From: Anthony.Collier@hertfordshire.gov.uk
Sent: 08 August 2017 11:02
To: Planning
Subject: Planning application 6/2017/1553/FULL - Computer Centre Uk Ltd

District ref: 6/2017/1553/FULL
HCC ref: WH/182/2017
HCC received: 20/07/2017
Area manager: Manjinder Sehmi
Case officer: Anthony Collier

Erection of a pedestrian turnstile gate and associated tarmac footpath

Proposed Site Layout - 1:200

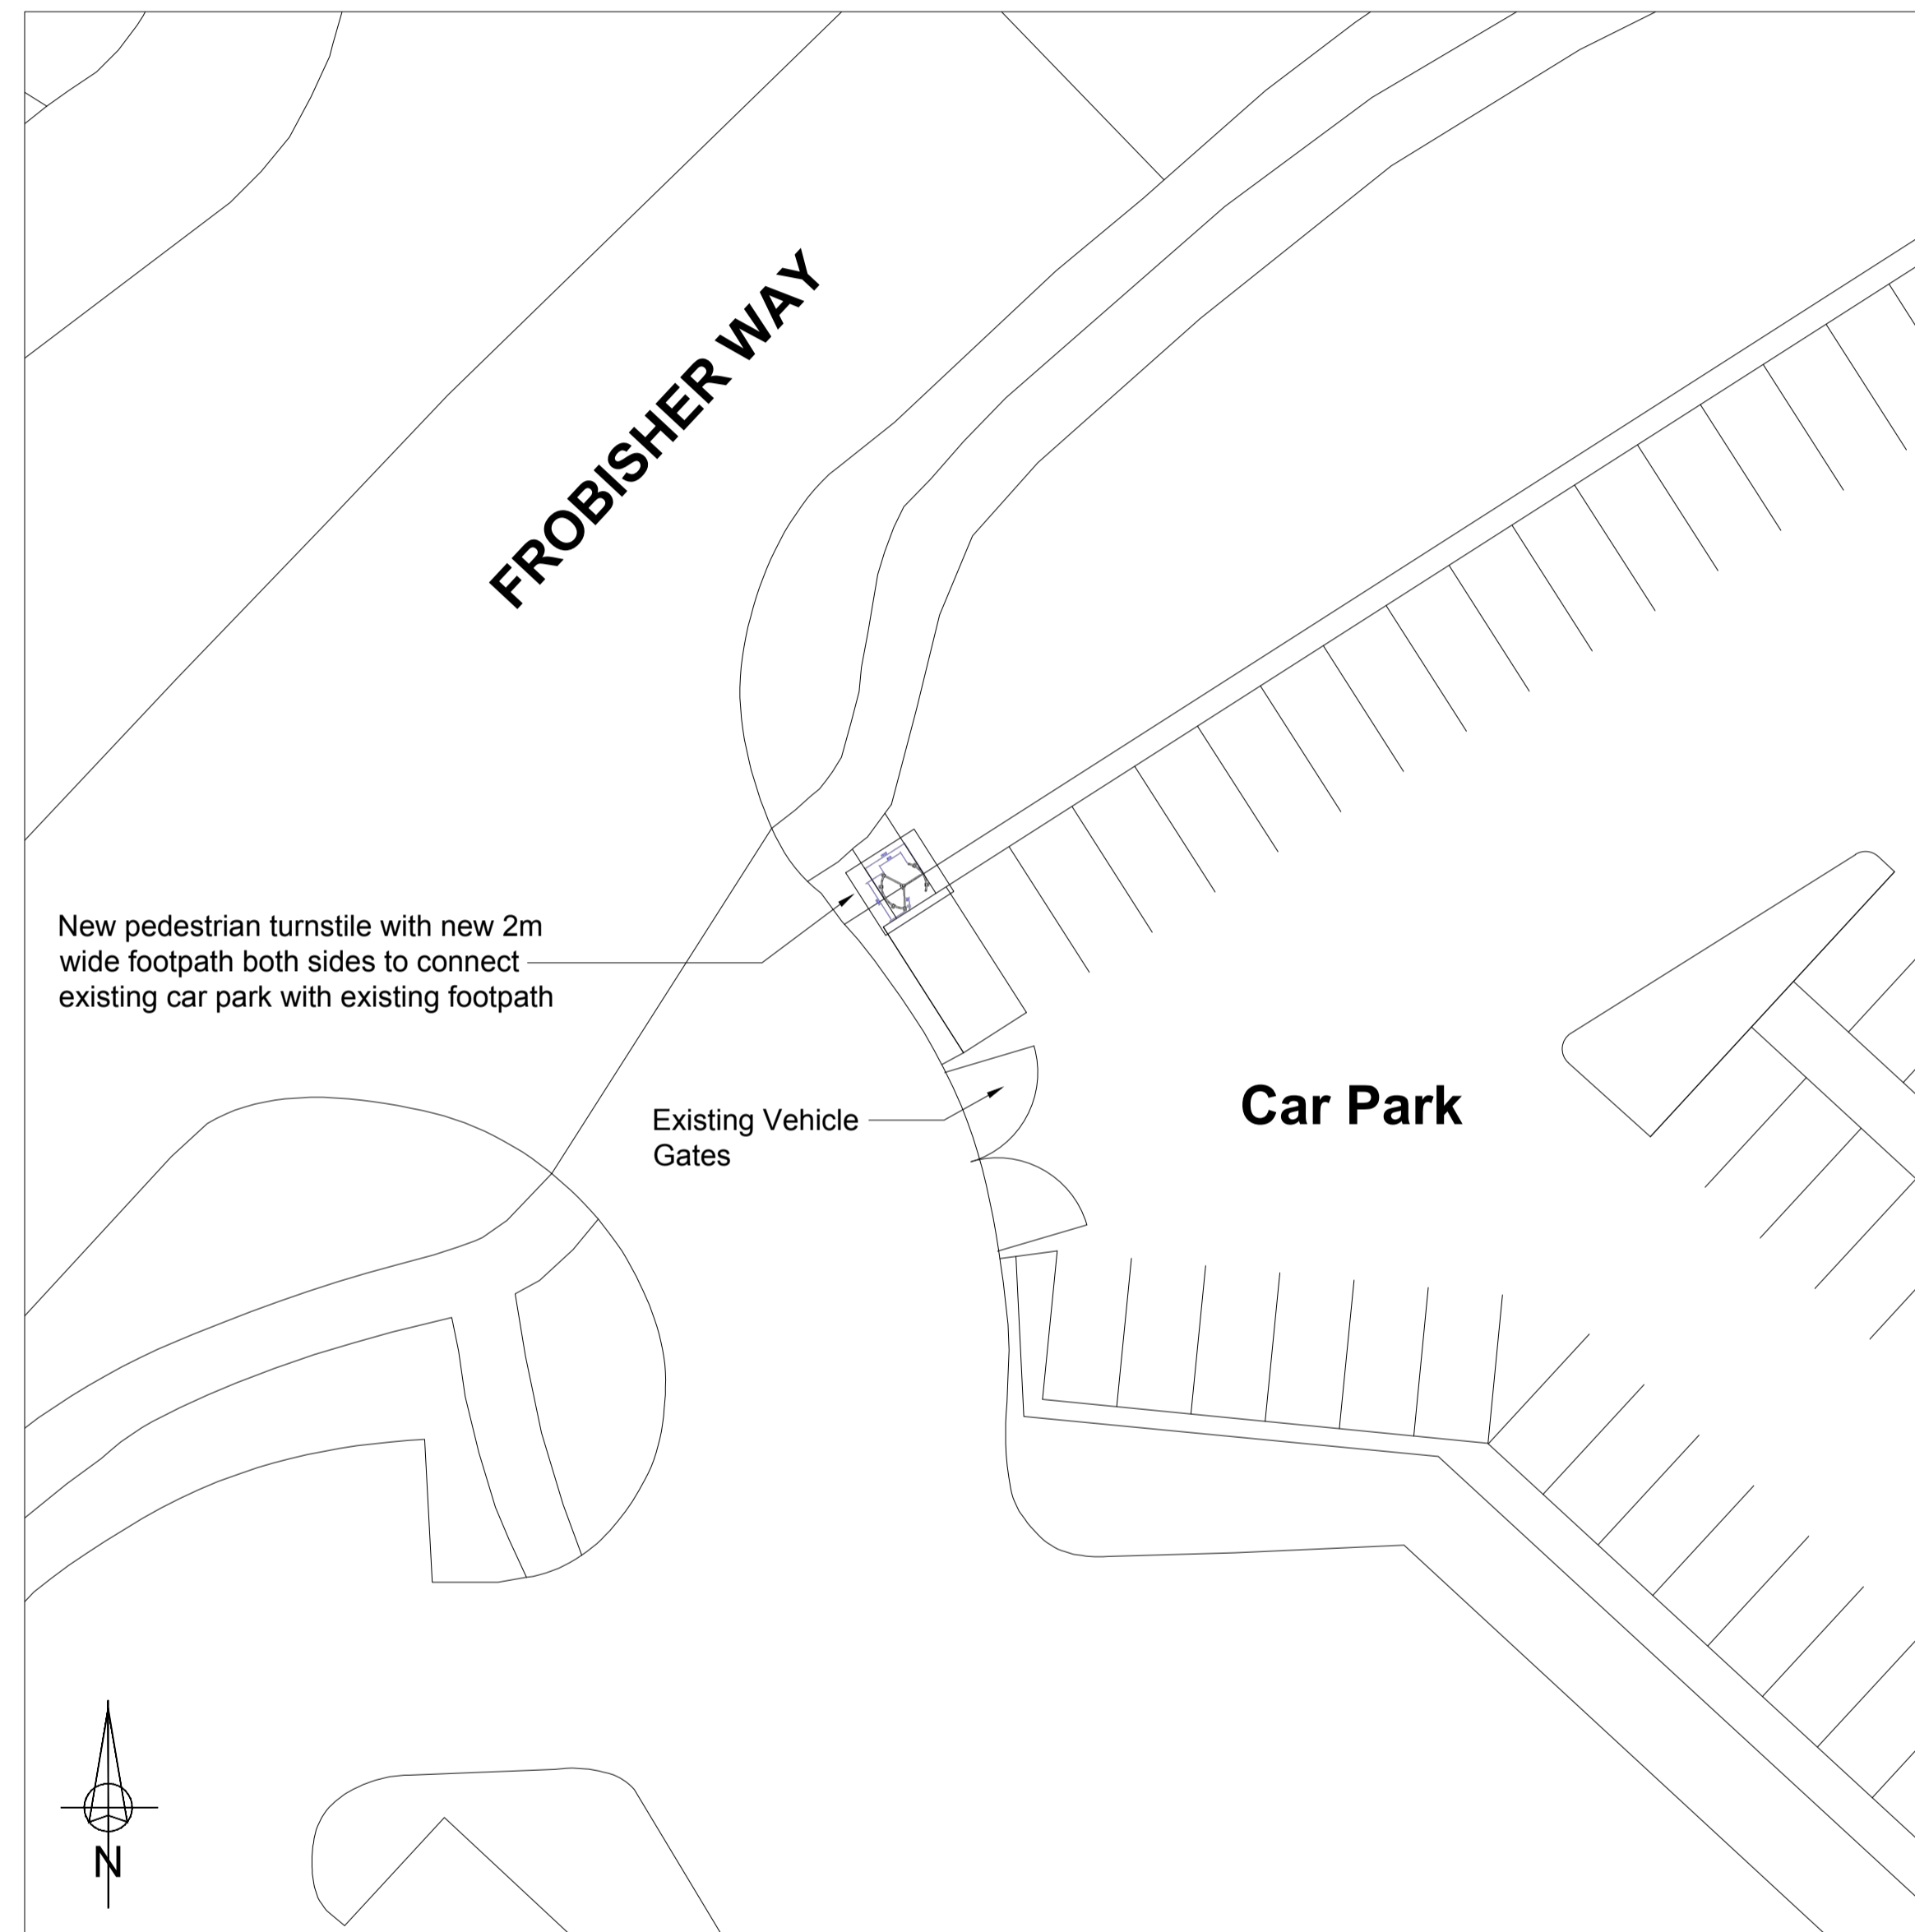
the access seeks to improve pedestrian accessibility by segregating vehicle and pedestrian access points, therefore removing safety concerns related to shared surfaces. the layout of the access path external to the site set out suitably, however it should be noted that the land it is to be built is not considered to have highway rights.

The internal arrangements remain acceptable, with no concerns over intervisibility raised through the proposal.
